COMMUNITY DEVELOPMENT DEPARTMENT
501 Delta Avenue ♦ Marysville, WA 98270 ♦ (360) 363-8000

Re: M-51 Industrial – *Technical Review 2*
PA 23014

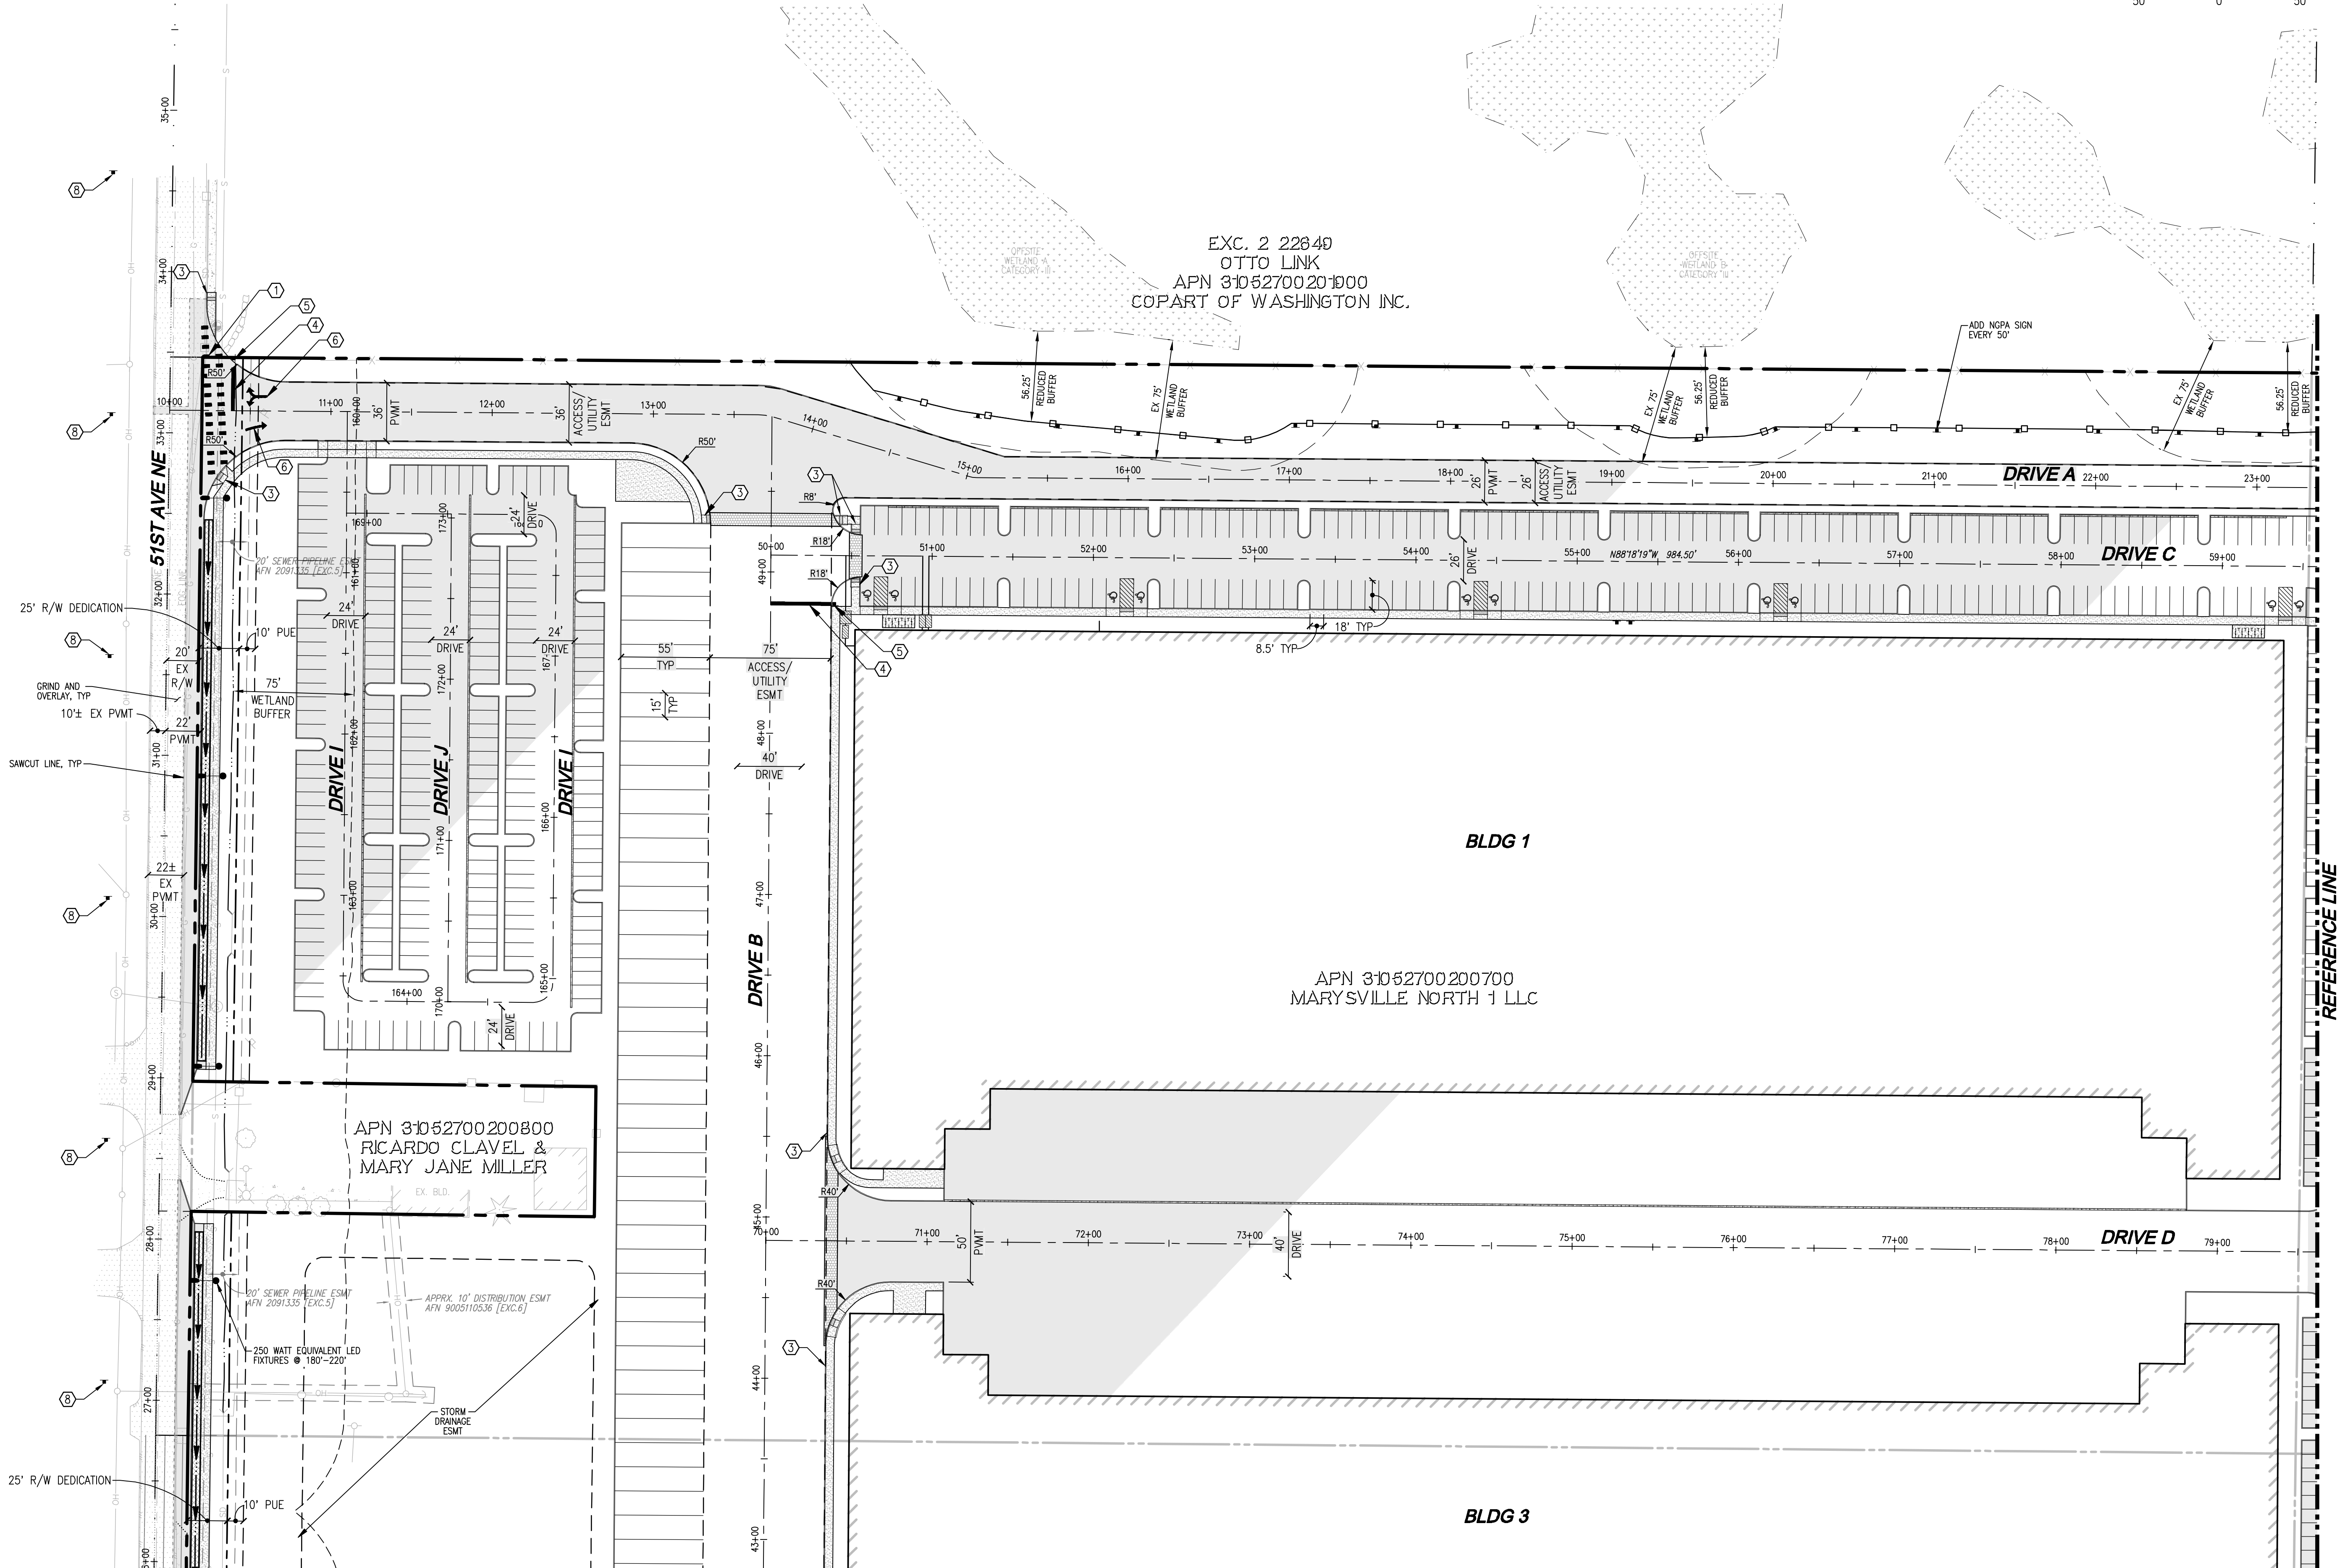
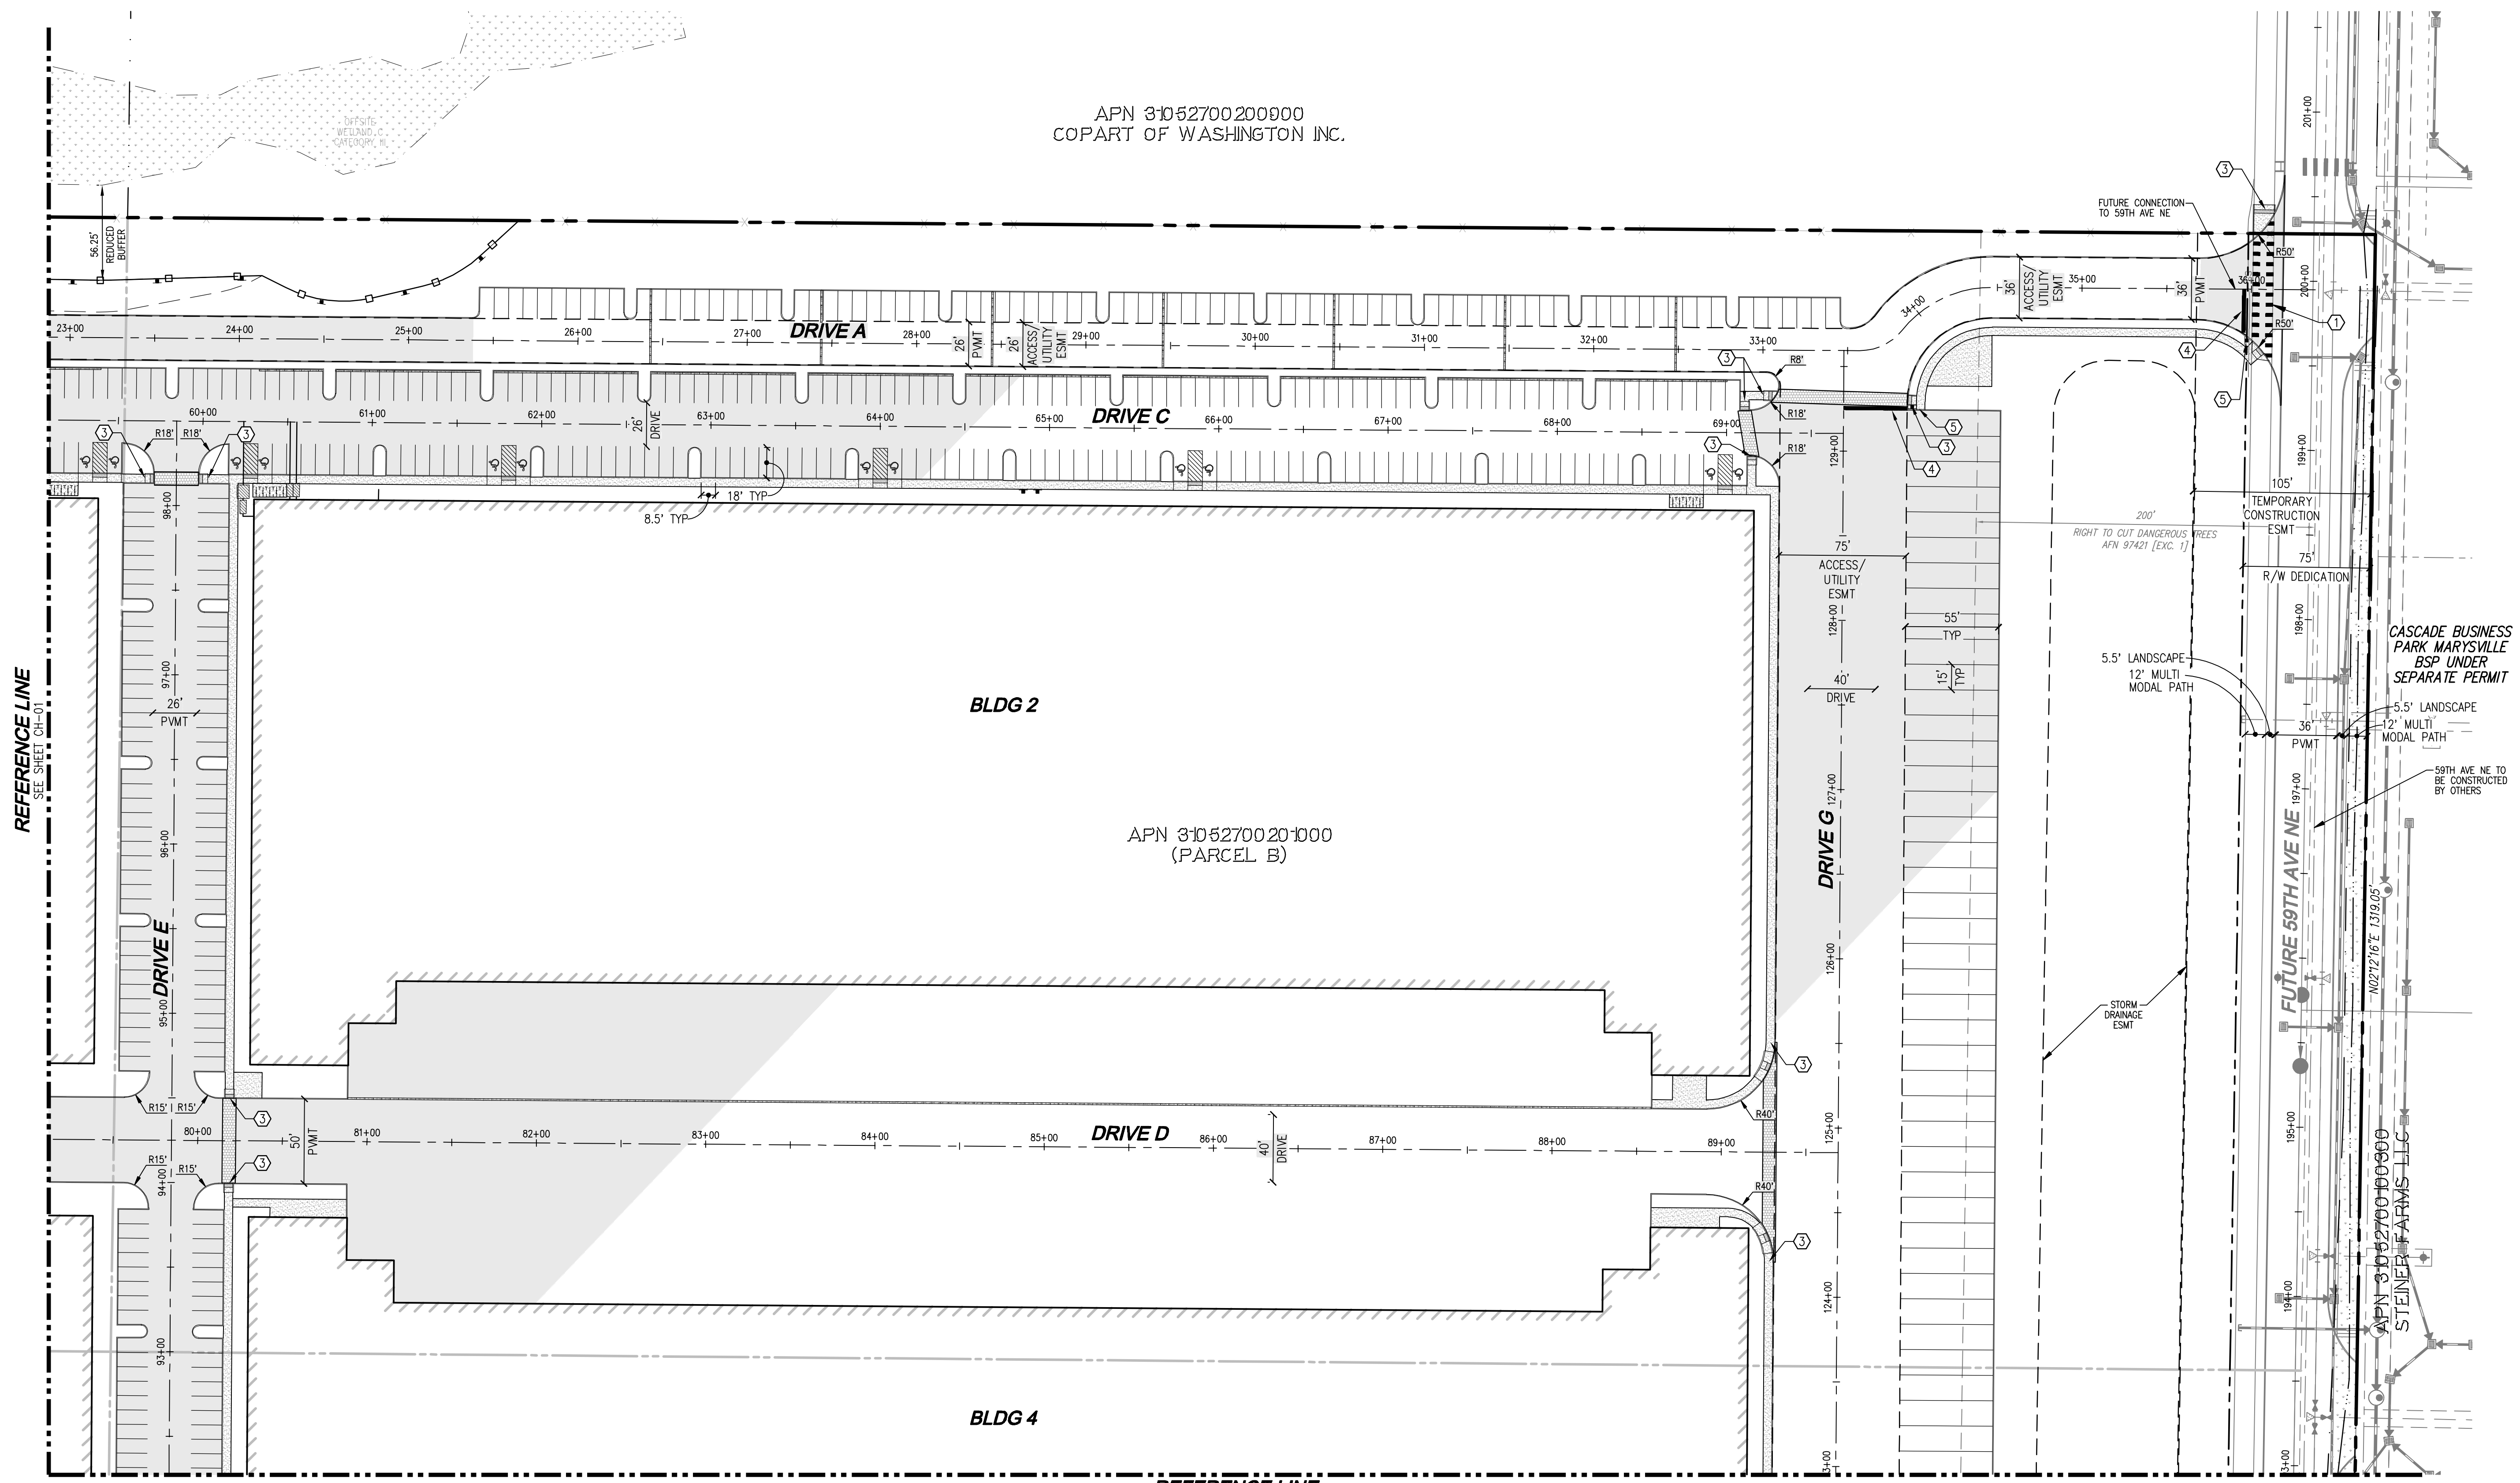
23. Conceptual street lighting shown on 51st Ave NE on combined utility sheet is highly inconsistent compared to previously provided typical spacing. No conceptual street lighting is shown on 59th Ave NE but will be required. This is acceptable for planning approval but shall be finalized during construction plan review.

- a. Street lighting shall be designed as minor arterial utilizing 250 watt equivalent LED fixtures.
 - b. Spacing of fixtures should be approximately 180'-220'.
